Re: BusConnects Belfield/Blackrock to City Centre Core Bus Corridor Scheme
Co. Dublin

Observation on a Strategic Infrastructure Development Application

Belfield/Blackrock to City Centre Core Bus Corridor Scheme

**TYPICAL SECTION V-V**  
**NUTLEY LANE**  
 LOCATED ON GA SHEET 22  
 DRAWING REF: BCIDC-ARP-GEO\_GA-1415\_XX\_01-DR-CR-0022

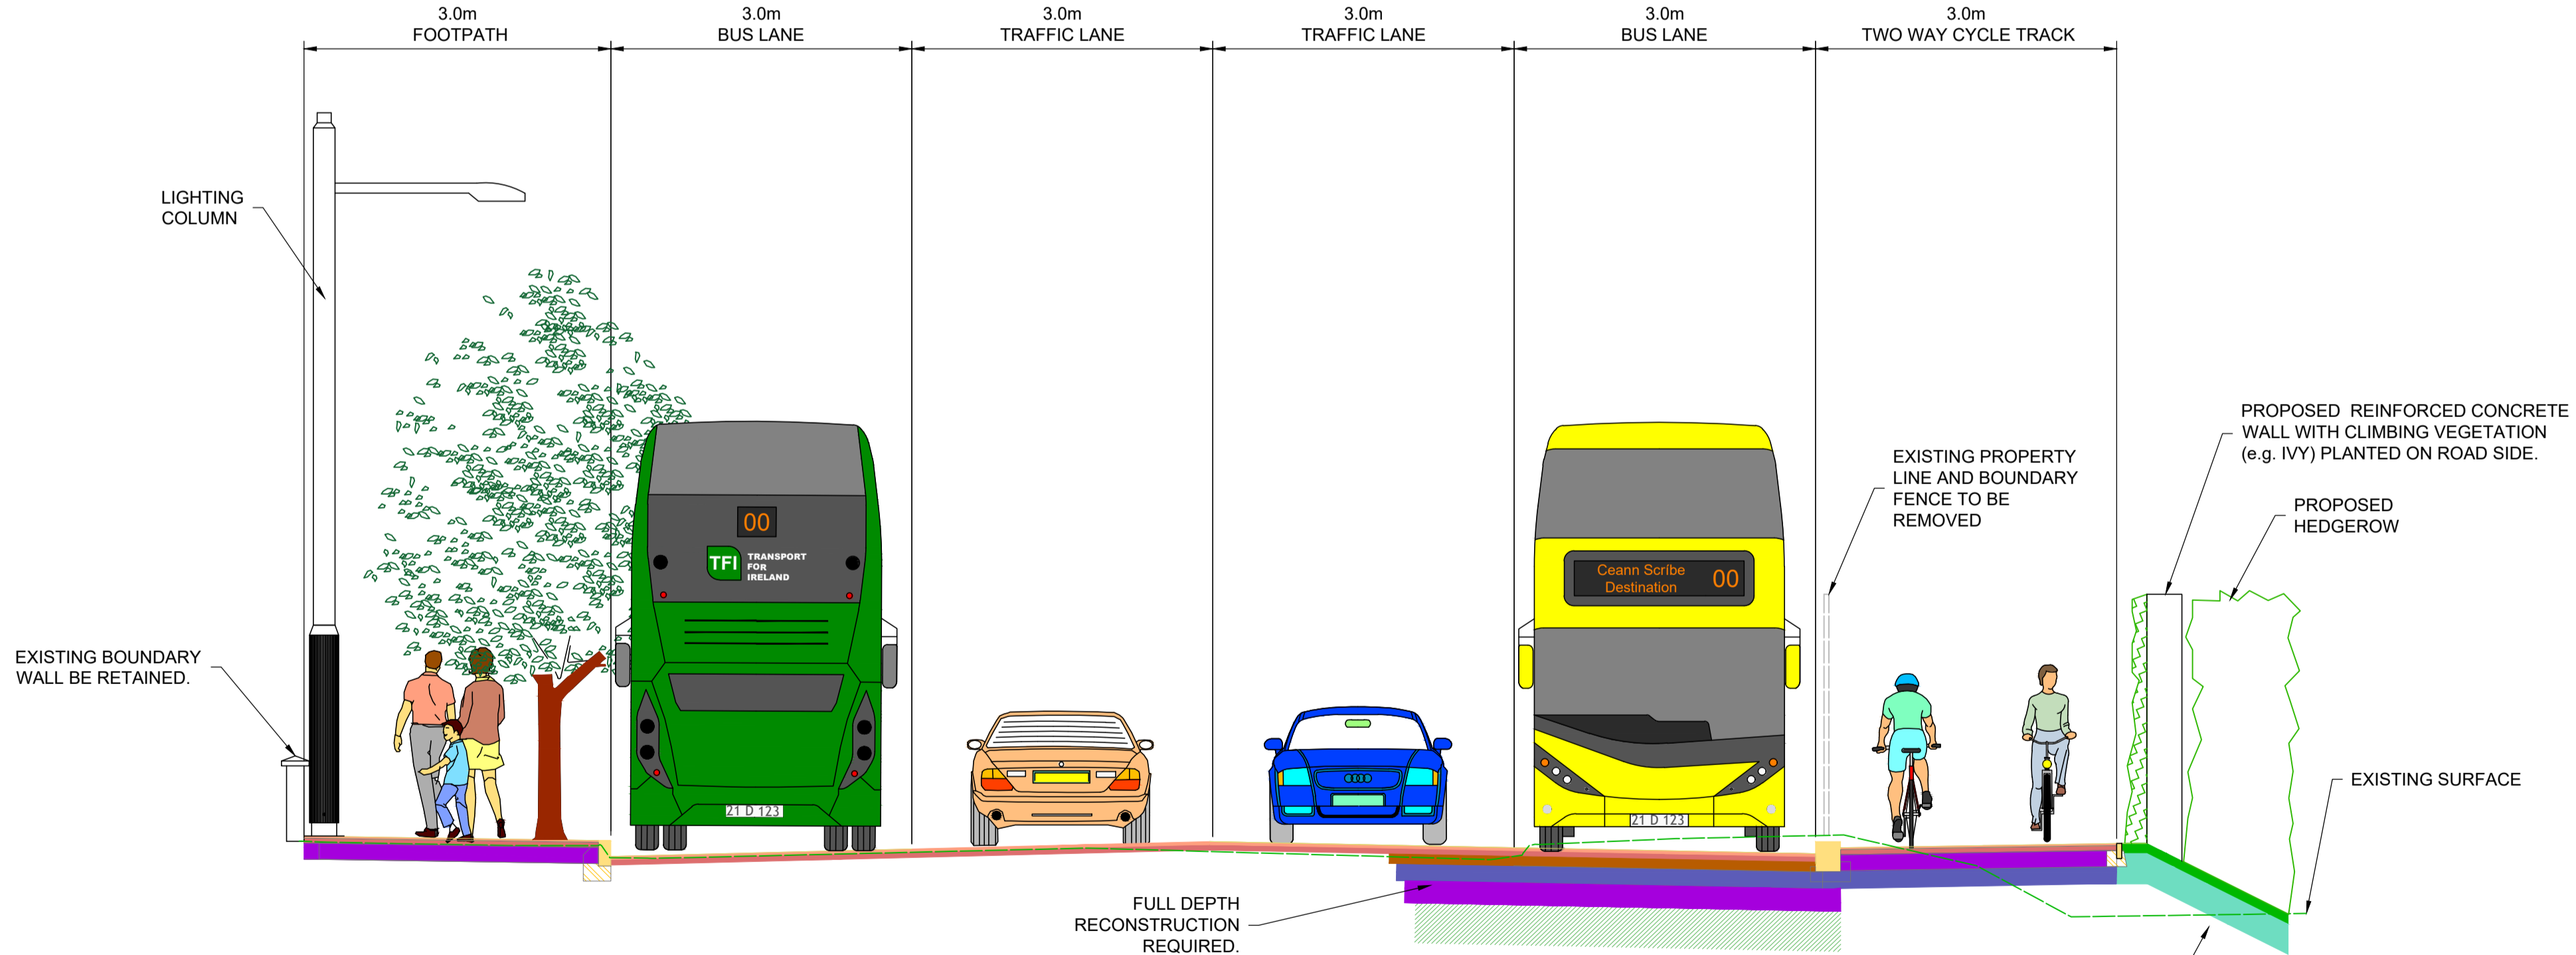
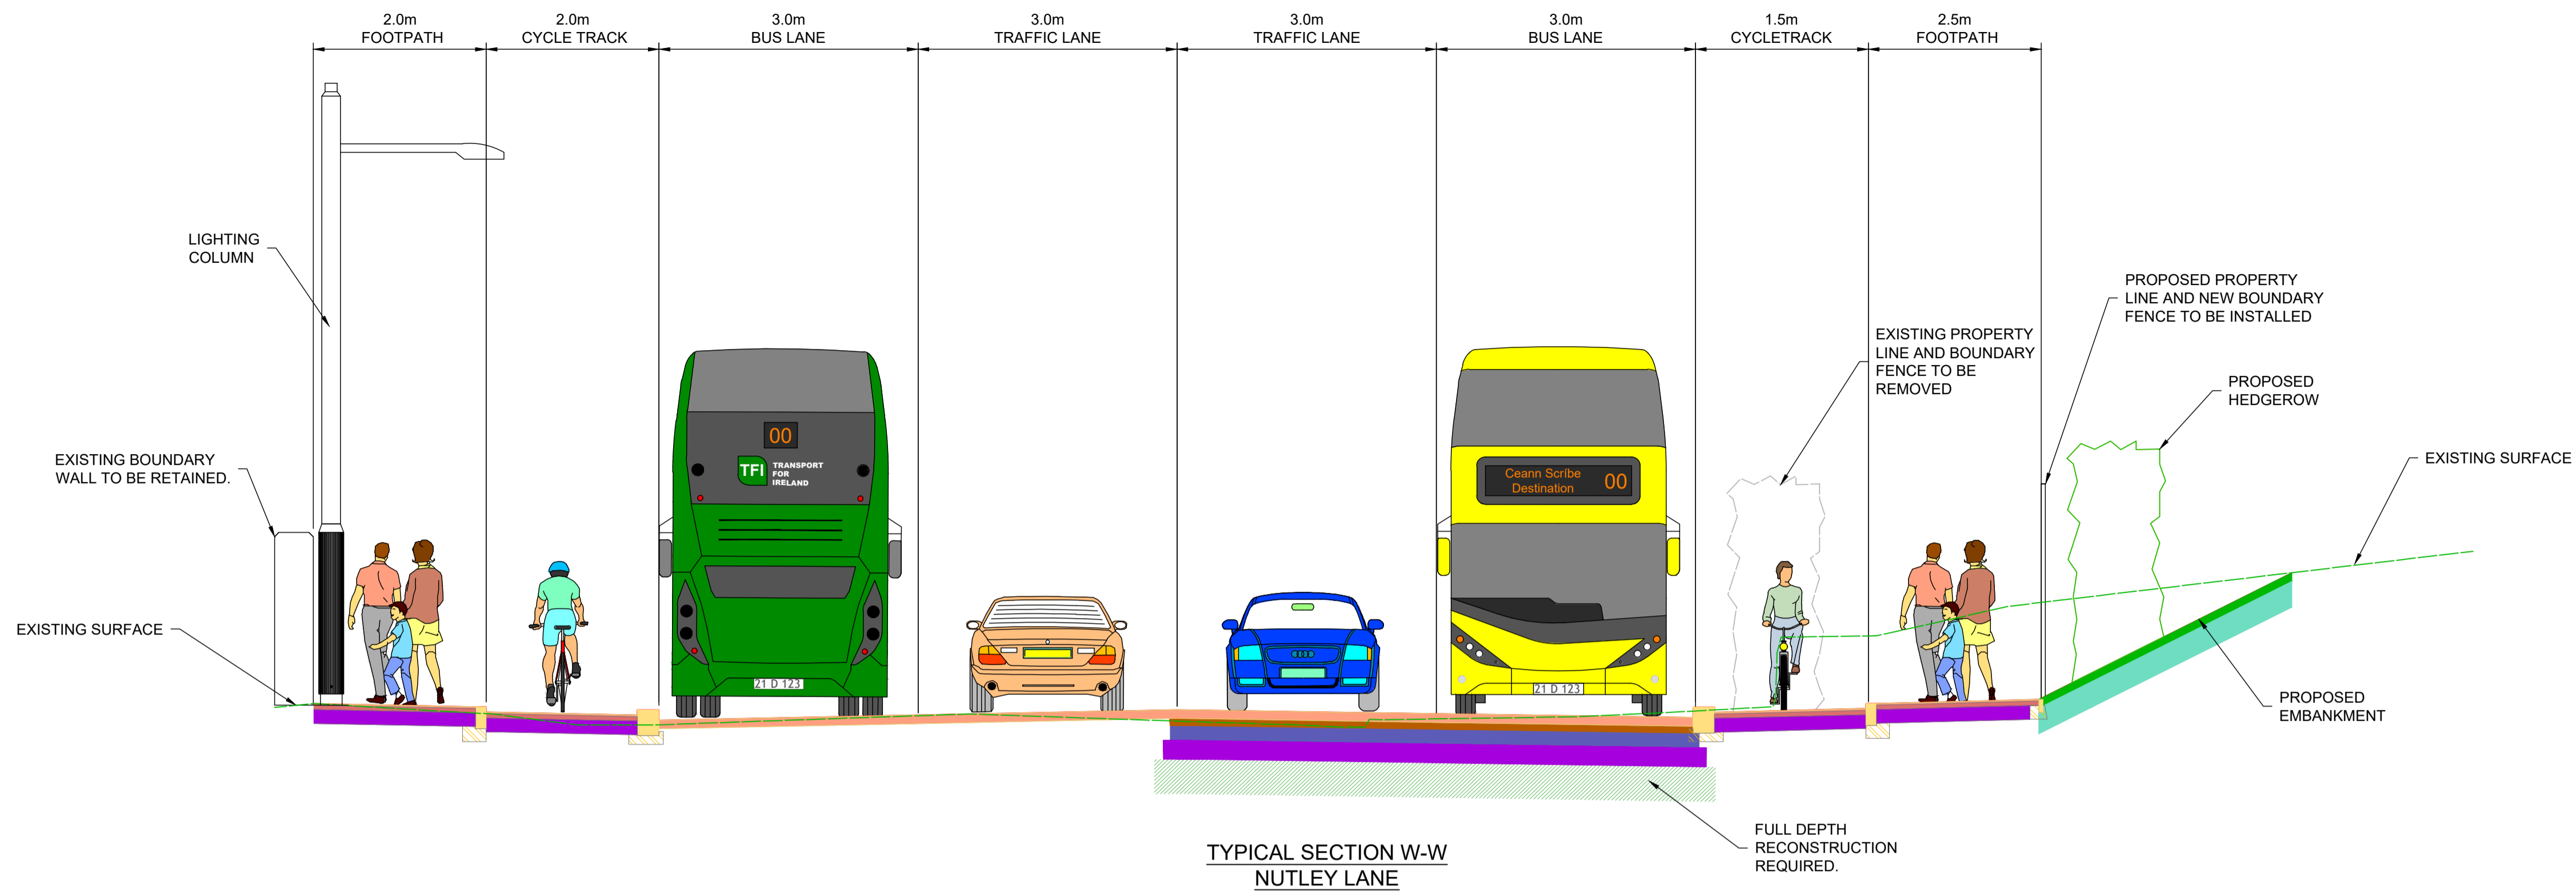
- Nowhere has a proper and cogent case been made for the conversion of a residential estate link road to a 4-lane highway plus 2 cycle lanes. We believe that the scale of the development in this residential area is unnecessary and that the addition of bus filter lanes at the top and bottom of Nutley Lane would substantially achieve the objective of speeding bus traffic. It seems to us that the NTA is trying to have a symmetry of 2 bus lanes, 2 car lanes and 2 cycle lanes wherever BusConnects is being introduced and we believe it is not necessary on Nutley Lane.

- The re-development of Nutley Lane as proposed will significantly degrade the local environment:
 - The "green" aspect of Nutley Lane will be seriously affected by the removal of very many mature trees. The mature hedging that separates Elm Park from Nutley Lane will also be removed and replaced with a stone wall. Visually, the Nutley area will be severely degraded by this loss of greenery.

- The removal of the footpath on the Elm Park side of the road will put too much pressure on the path on the opposite side of the road where it is currently difficult for 2 people to pass each other.

- The original BusConnects proposal that was presented to the public and on which opinions/submissions were sought envisaged the dual cycle path on Nutley Lane coming up on the Elm Park side of the road before crossing over to the opposite side after it passed the gates of Elm Park. On 12th May we were informed that an application was being made to An Bord Pleanála in relation to the Belfield/Blackrock to City Centre Core Bus Corridor Scheme and the letter outlined a number of amendments to the original proposal but without mentioning that the route of the cycle path had been changed. It is now not to cross the road but to continue straight up the Elm Park side of the road until it meets the Stillorgan Road. We consider this a very material and regressive change and cannot understand why it wasn't notified before the planning application had been made. Quite simply, the dual cycle paths now pass the front gates of 8 residential houses whereas previously, they passed the gates of only one premises on the other side (RTE's gates are now inactive). While it will make access and egress from these 8 houses more difficult (and there are constant vehicle comings and goings from these houses due to school, work, shopping trips, etc and one of the premises houses a handicapped child where it is necessary for a care vehicle to pull up outside) we consider that from a cyclist's point of view the change can only be viewed as rendering the cycle paths much more hazardous. We believe that there inevitably will be accidents with vehicles coming in and going out of these 8 houses and having to cross the cycle paths. We believe that the original proposal to have the cycle path cross to the other side of the road is the only sane one.
